Application for a non-material amendment following a grant of planning permission.

Proposed construction of 1 no. 3 bed chalet bungalow utilising existing access.

Application Ref: FG/121/09/

Change to style of window fenestration by omission of the horizontal glazing bar, addition of sidelights to the french doors to the rear (south) elevation, enlargement of the window to the side (east) elevation, change of roofing to conservatory to plain tiled roof with roof windows.

drawing no. **12017/16E**

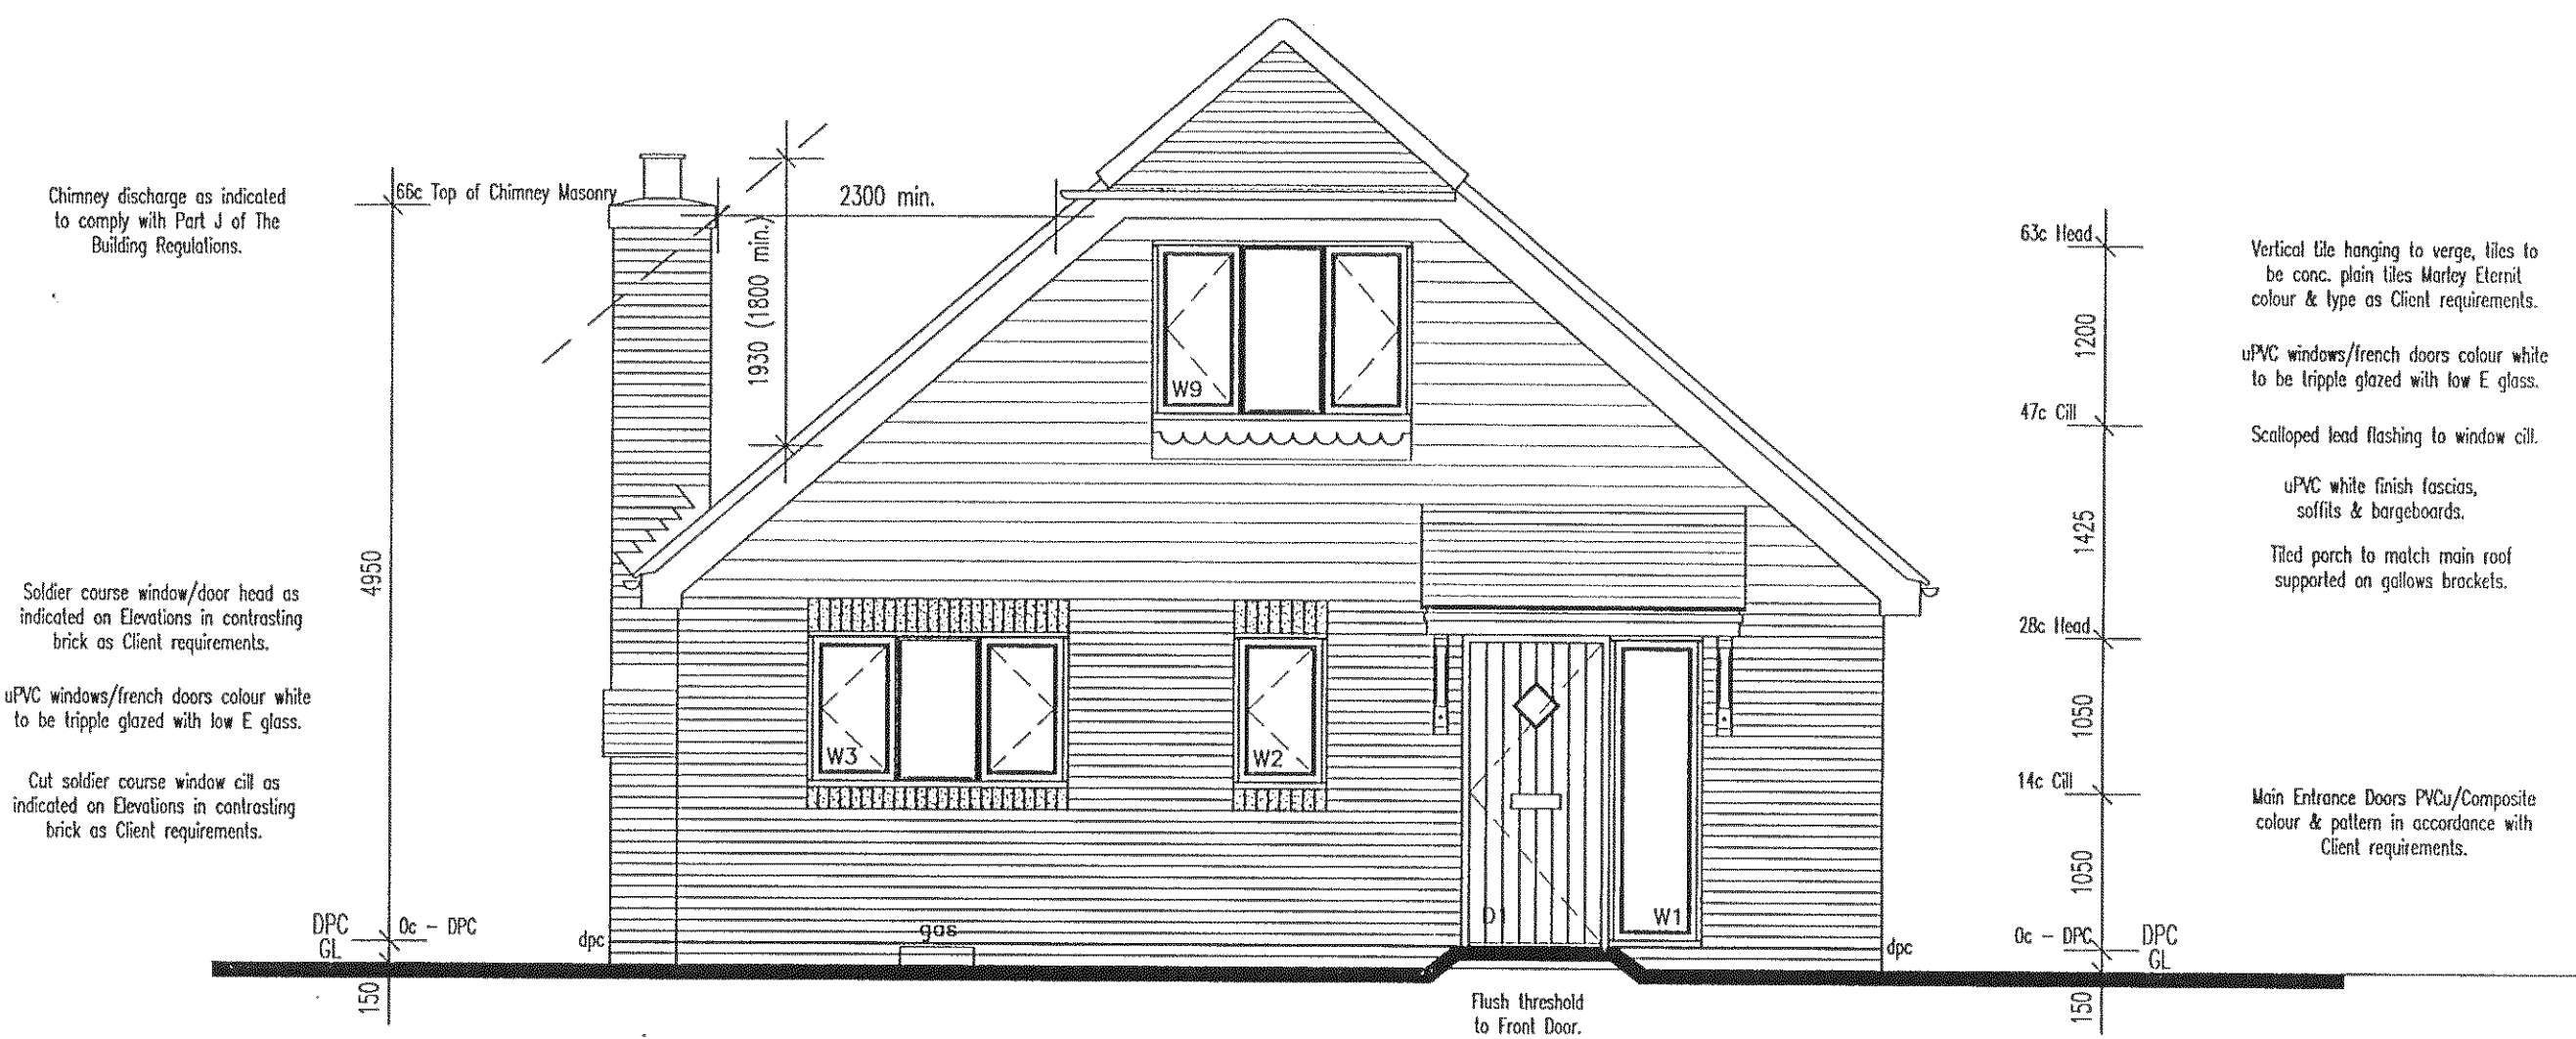
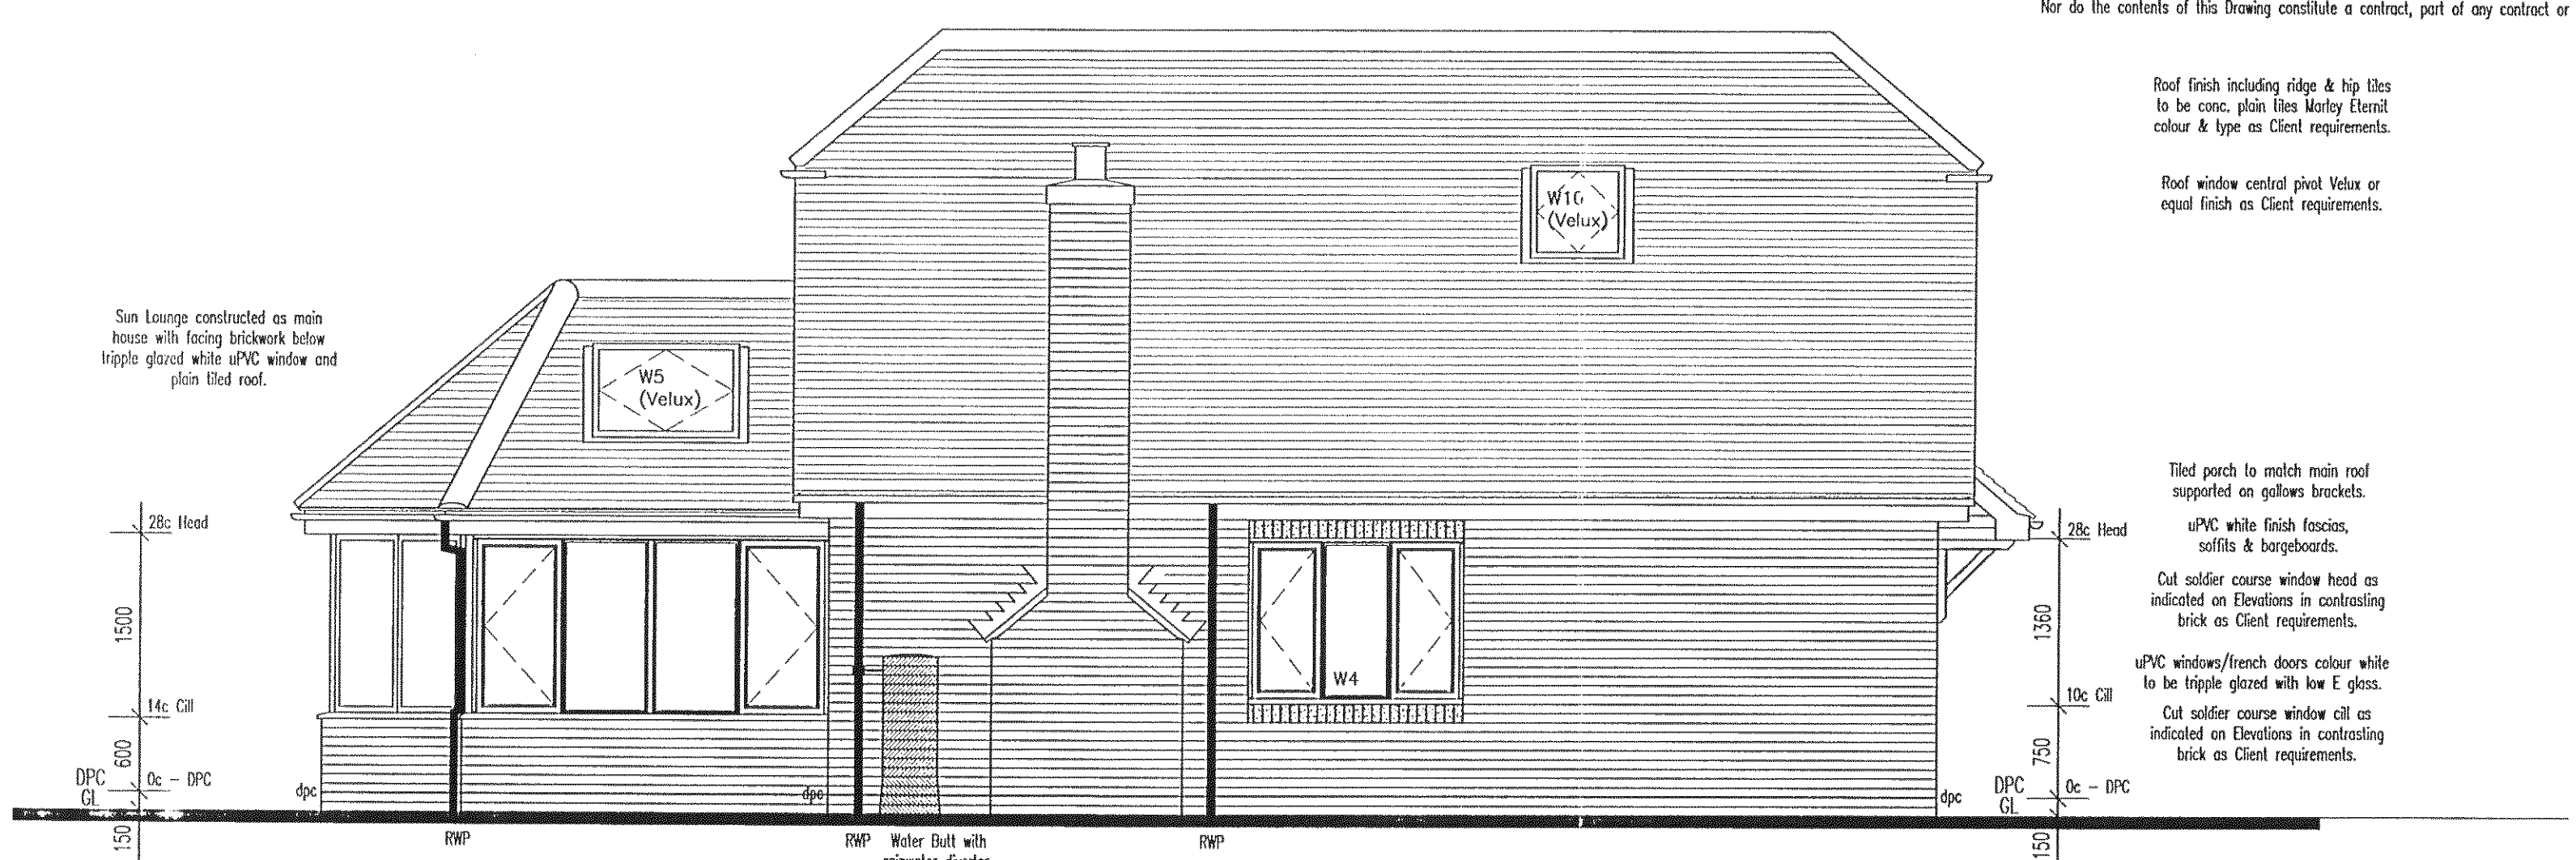
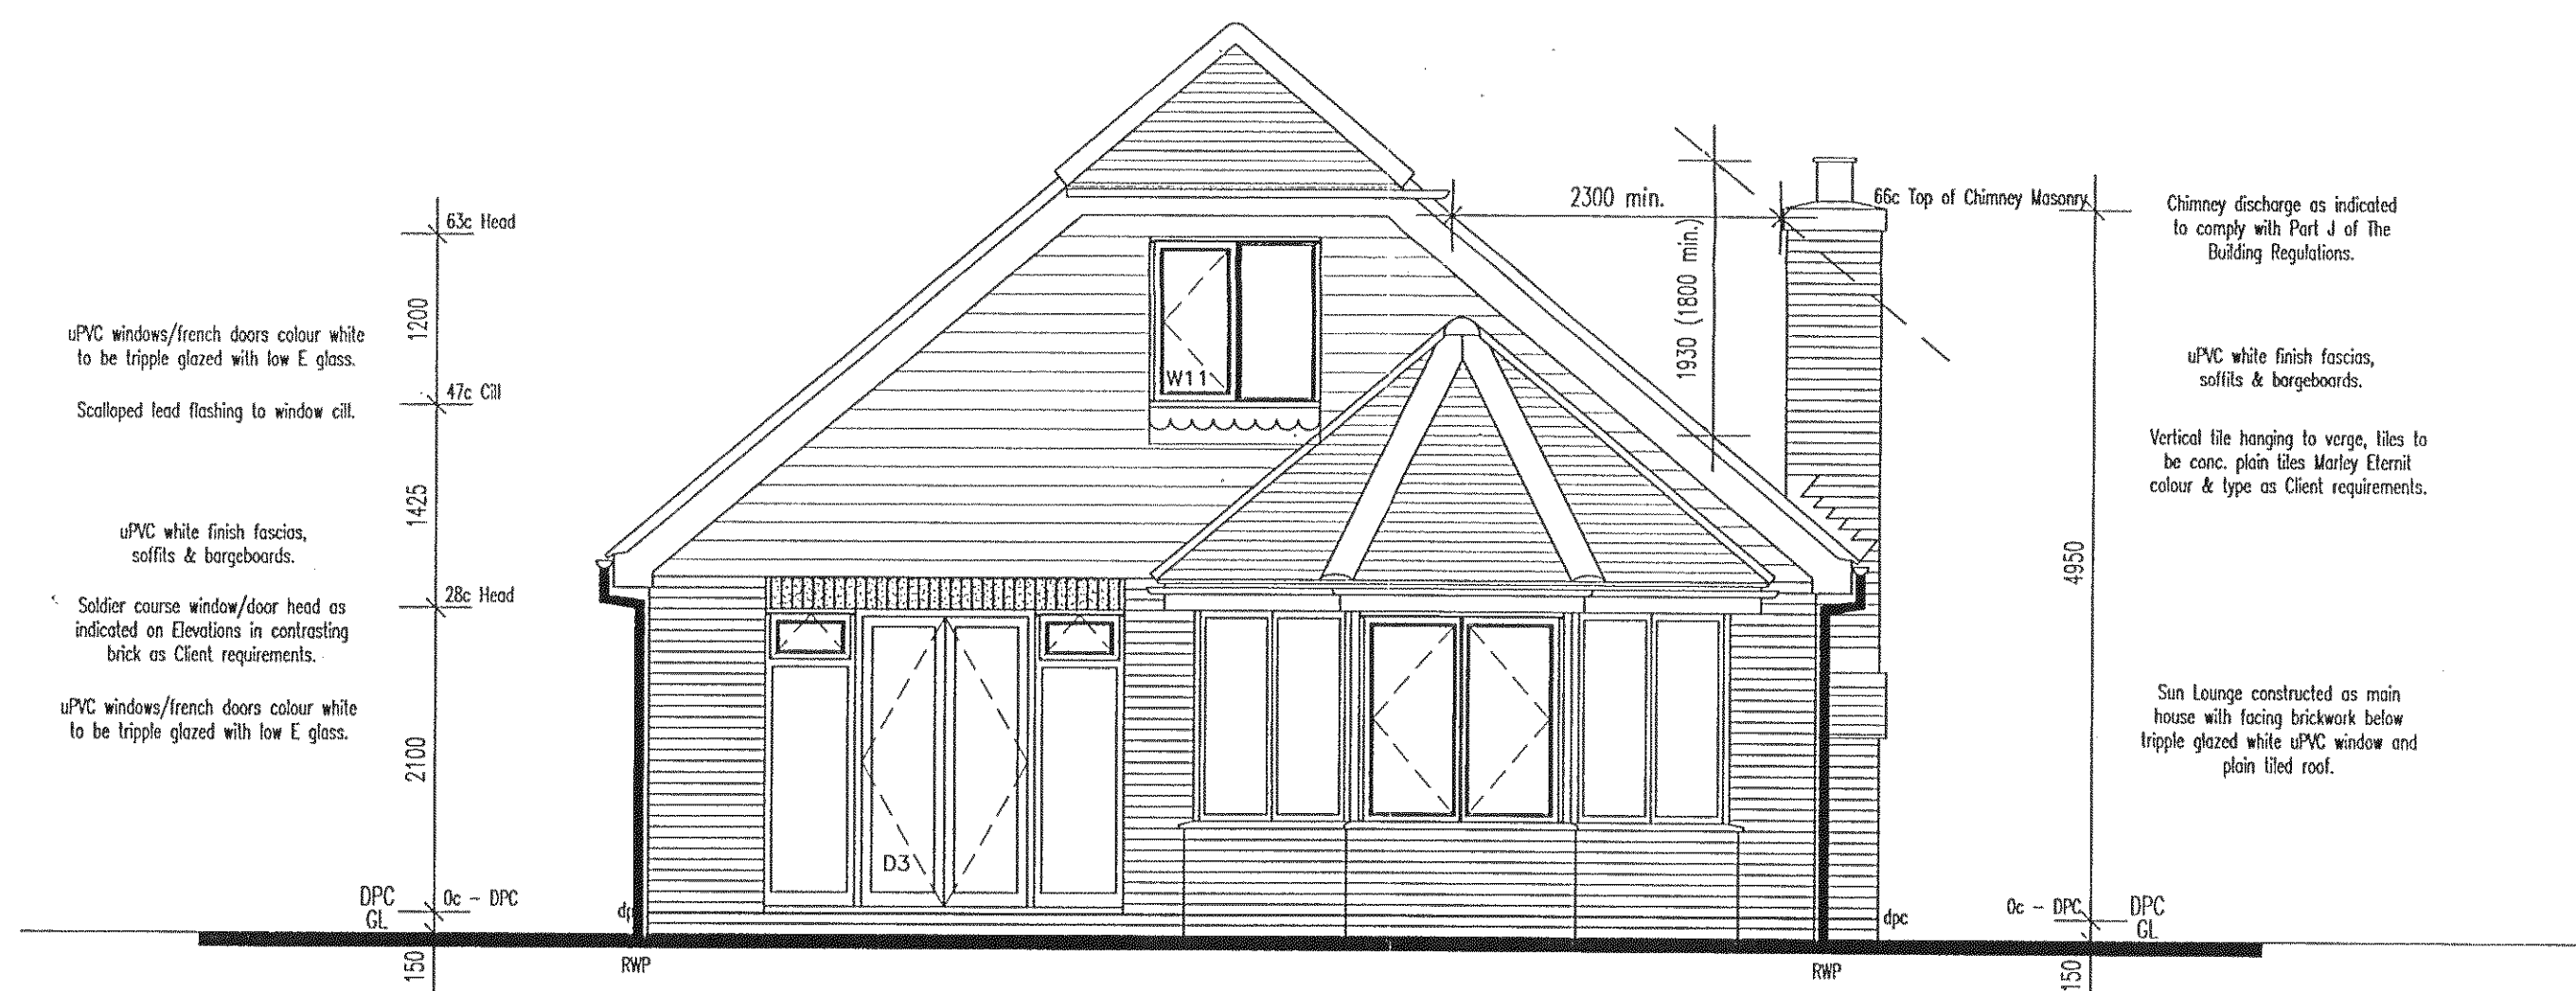
Omission of the horizontal glazing bar to facilitate use of energy efficient tripple glazing, sidelights to the french doors to the rear (south) elevation to provide room with more daylight, enlargement of the window to the side (east) elevation to provide more light to living room, conservatory plain tiled roof with roof windows to provide sun room in place of conservatory.
